**Consultation Response from KC,  
Lead Local Flood Authority**

**2024/92806 Land at, Penistone Road, Fenay Bridge, Huddersfield, HD8 0AW**

**Discharge of details reserved by conditions 20 (surface water discharge), 21 (flood routeing) and 31 (grass-crete and batter maintenance) of previous permission 2022/93154 for erection of 68 dwellings with associated access, parking, open space, landscaping and infrastructure works (including installation of surface water attenuation tank)**

**Date Responded: 7<sup>th</sup> February 2025**

Title: Outfall Headwall Details
Headwall1 HW1

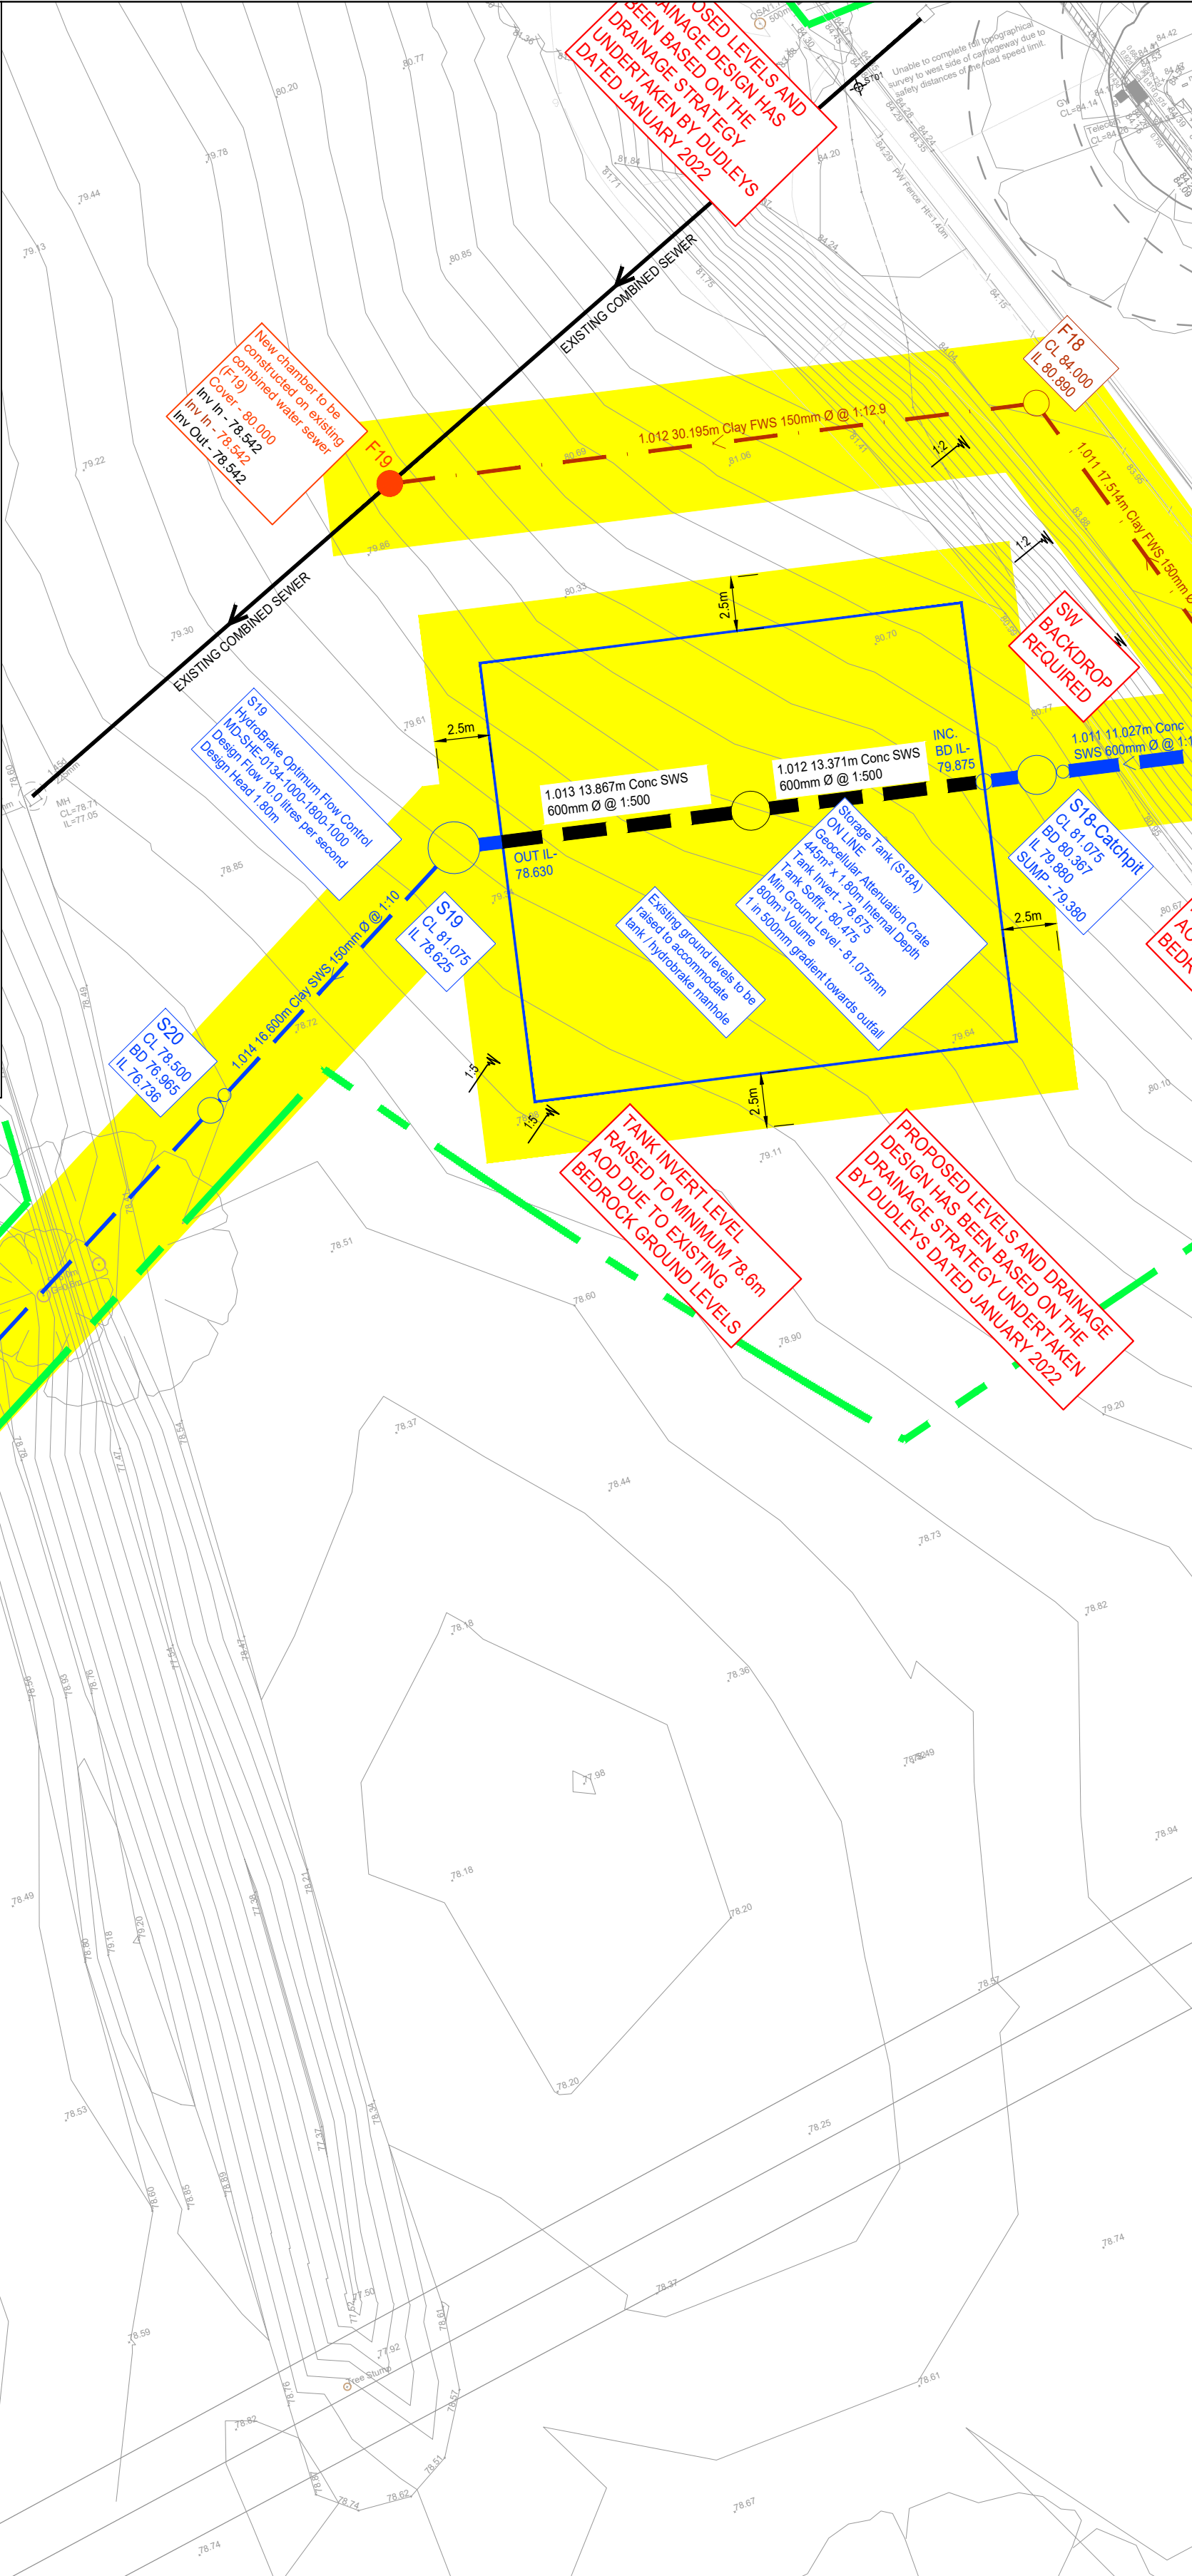
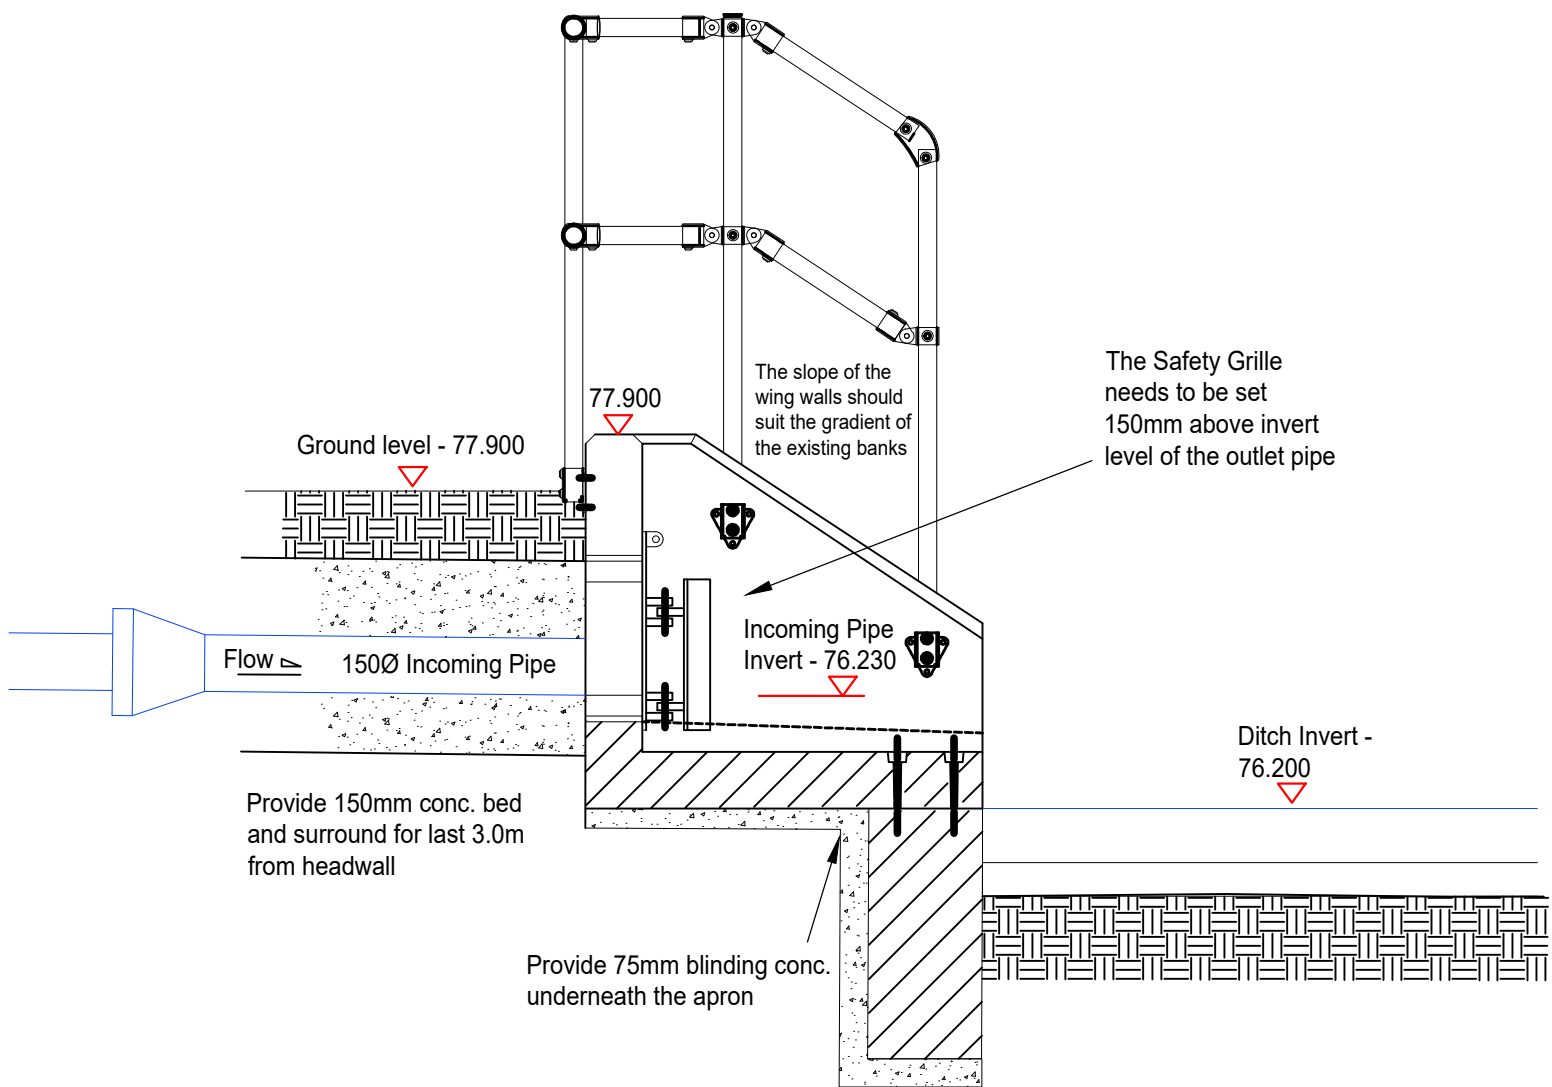
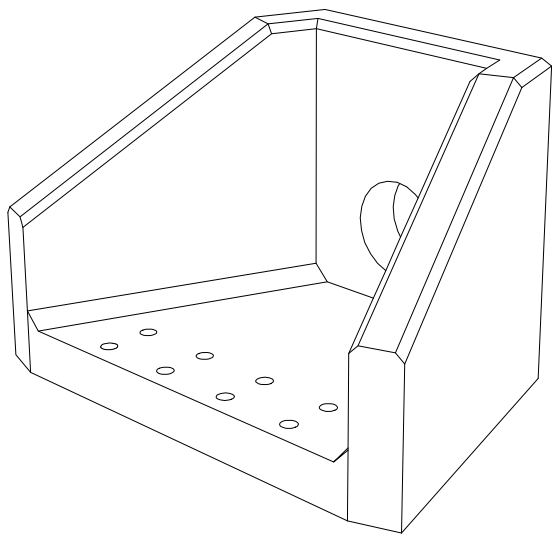
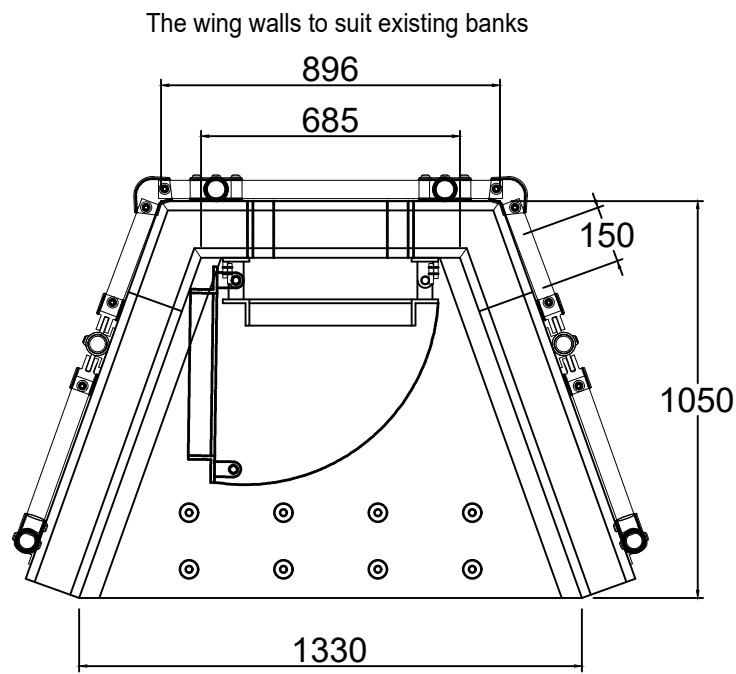
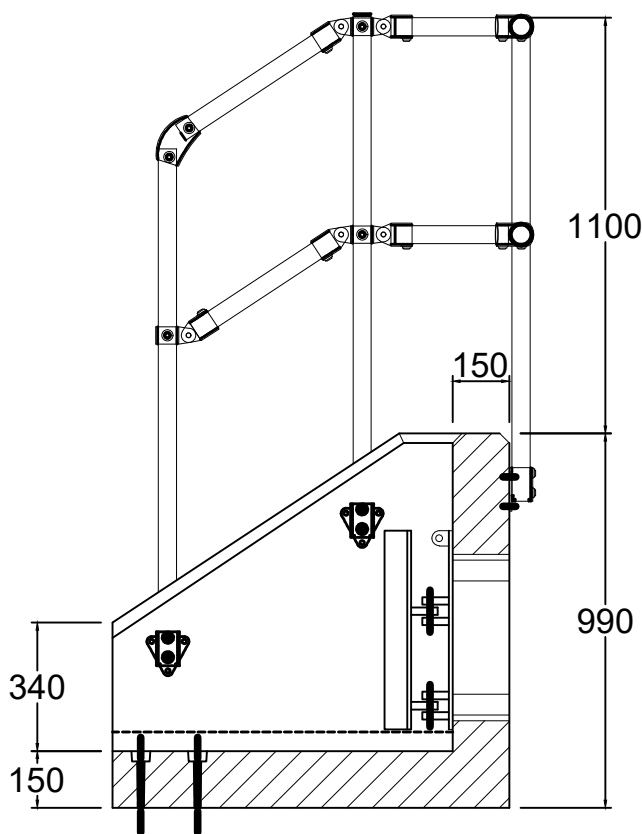
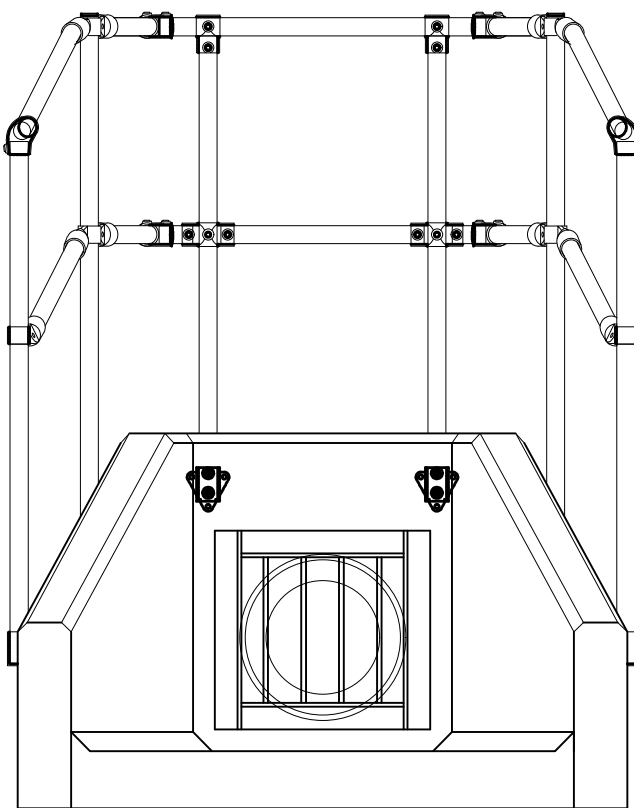
Clarification of the outfall details are required. 150mm above existing typical water level is required. There is reference to only 30mm above ditch level. Connection should be to a watercourse. A safety grille is mentioned where a flap valve should be provided. We are concerned given the level above bed level, that this valve could be shut more often than is desirable. A separate submerged outfall simulation is required. An addition spill inspection chamber prior to the outfall may be required.
